Application No: A/164/21/AG
Site Address: Land south of Littlehampton Road Angmering BN12 6PN
Description of works: Notification under the Town & Country Planning (General Permitted Development)(England) Order 2015 under Schedule 2, Part 6, Class B(d) to upgrade existing agricultural track, providing access to Roundstone Farm.

My Council has considered the above application and wishes to wholeheartedly support the objection/comments submitted by the Angmering Parish Council as follows:-

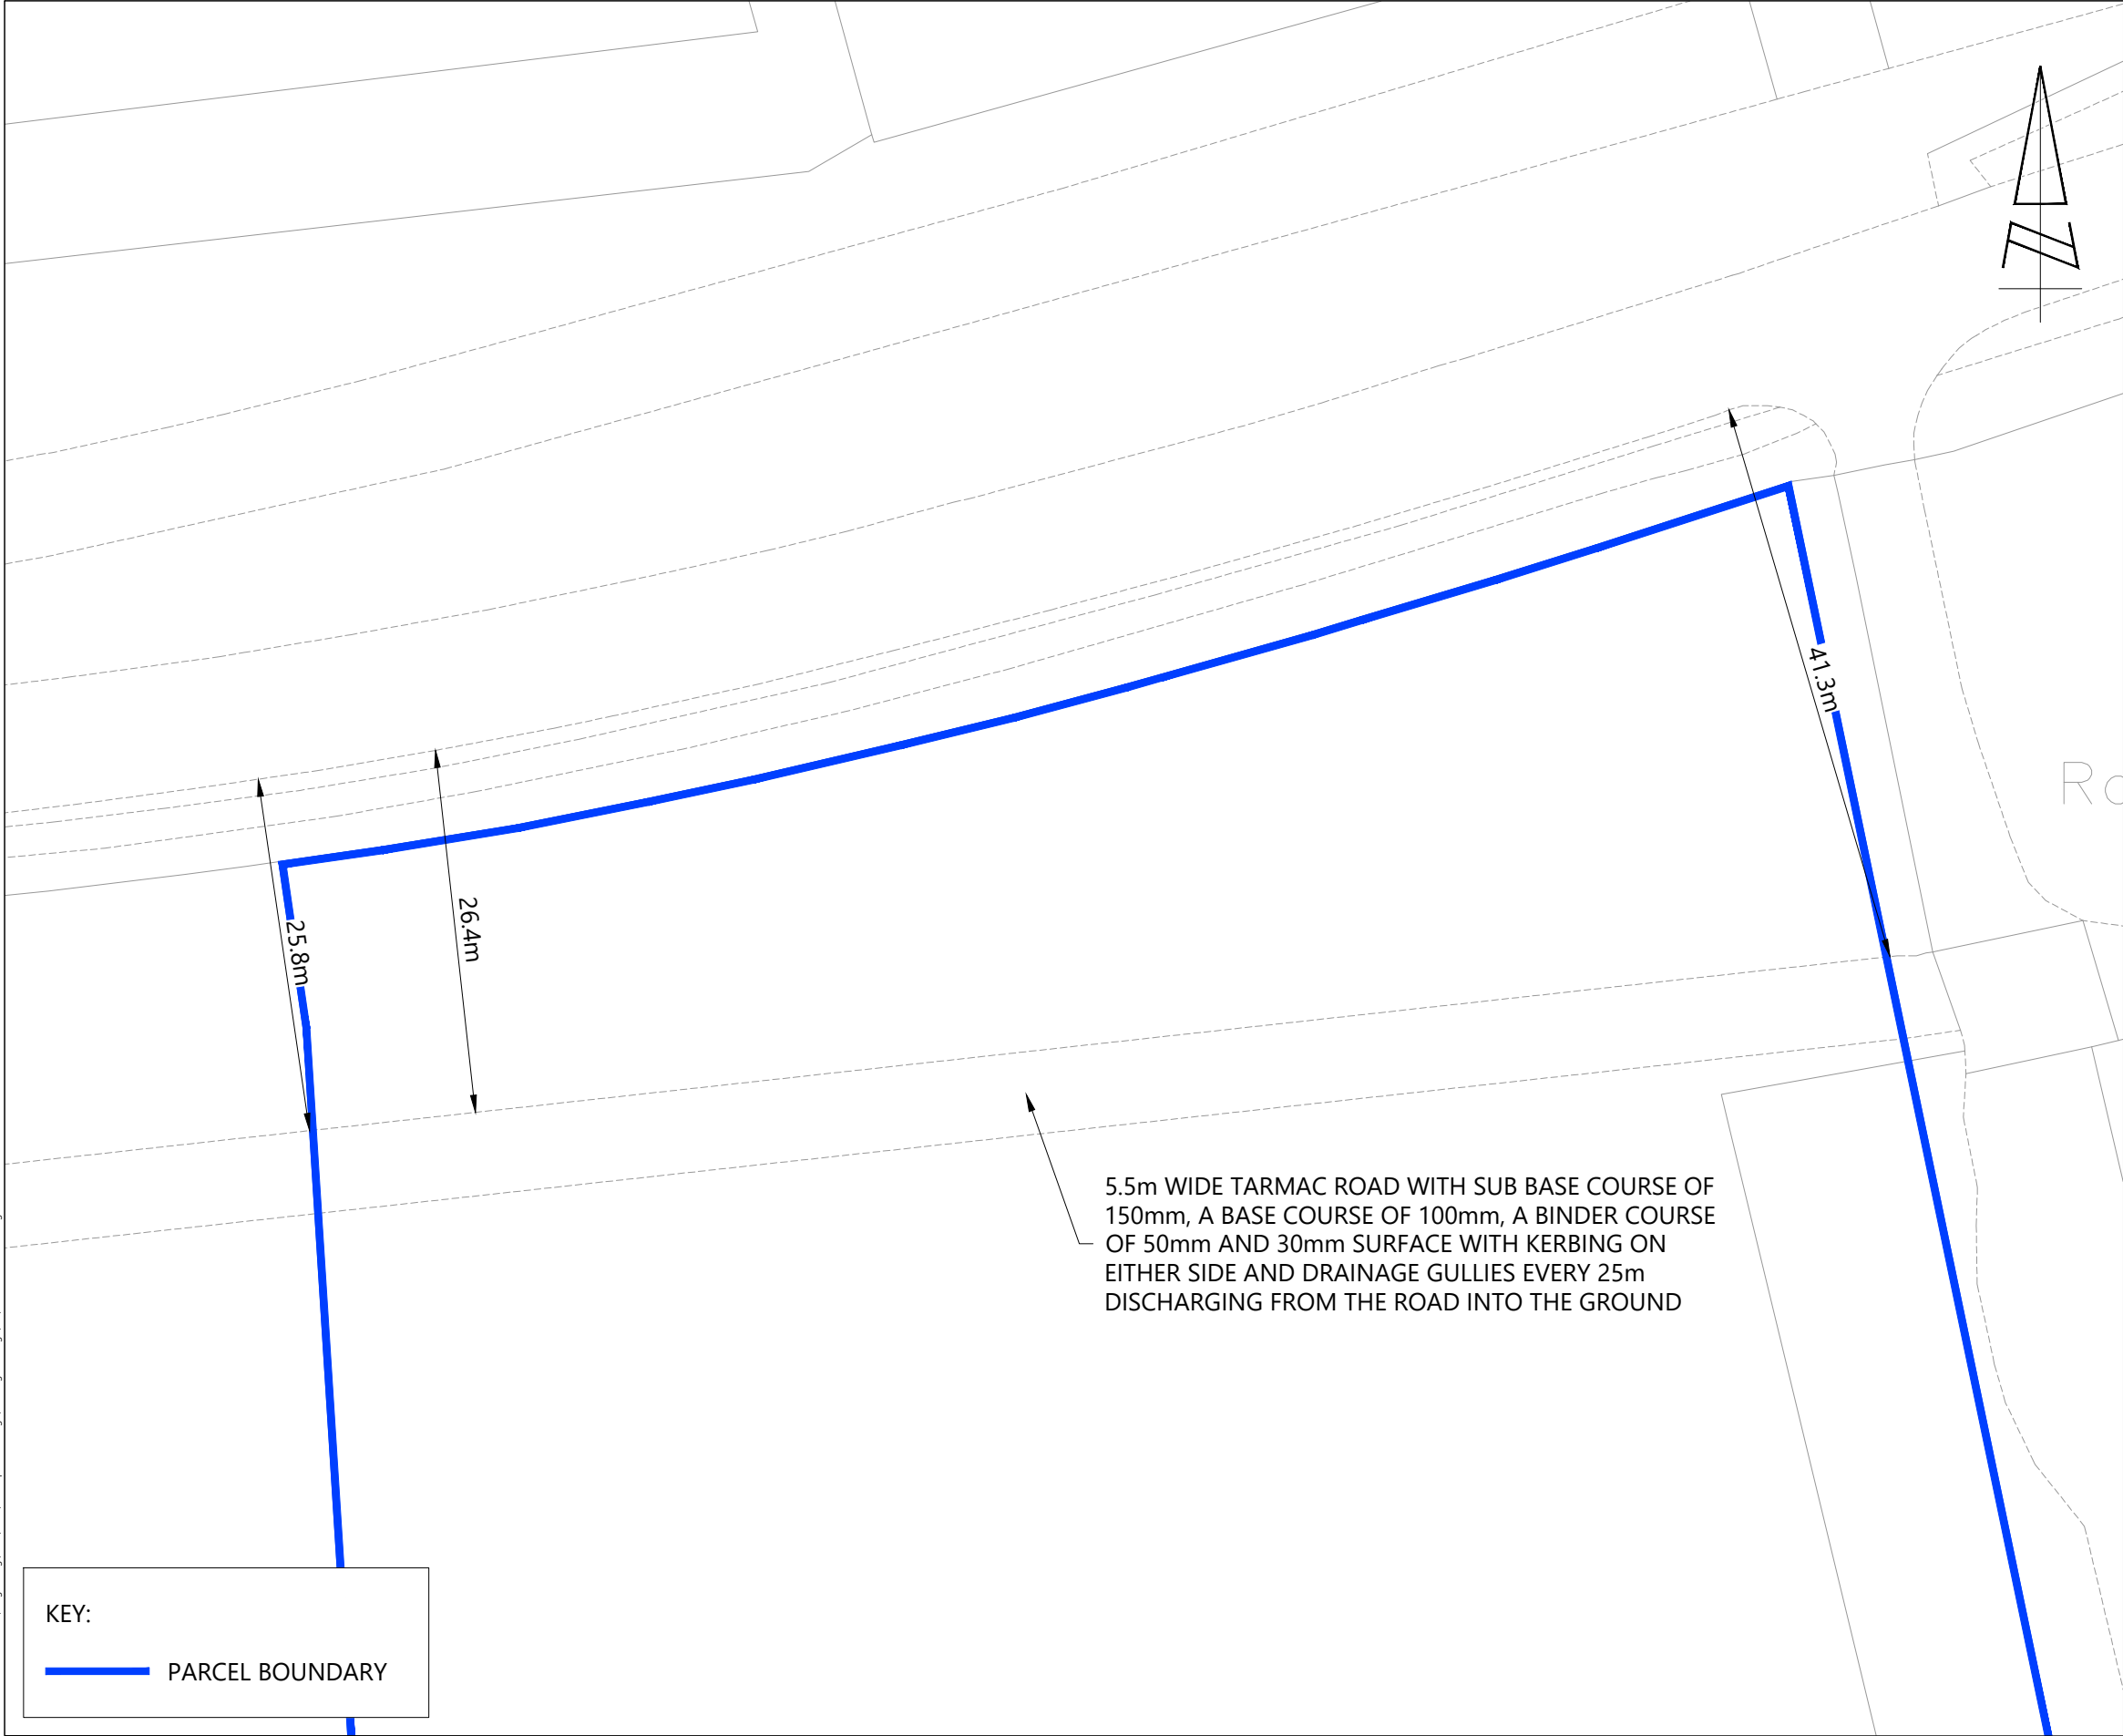
"On inspection today (24/08/21) by an APC Councillor, a Chartered Civil Engineer, this farm road seemed to be in a satisfactory condition for the farm traffic that currently use it. There seems to be absolutely no need to kerb and construct it to the standard proposed. It does seem that this could be an attempt to progress application A/168/21 for 76 houses on the site prior to determination. If ADC is minded to grant this application it should be conditional that the road's present and future use should be restricted to farm vehicles only and on no account used by any other vehicles accessing the farm, for any purpose, from the A259 or the A280/A259 Roundabout."
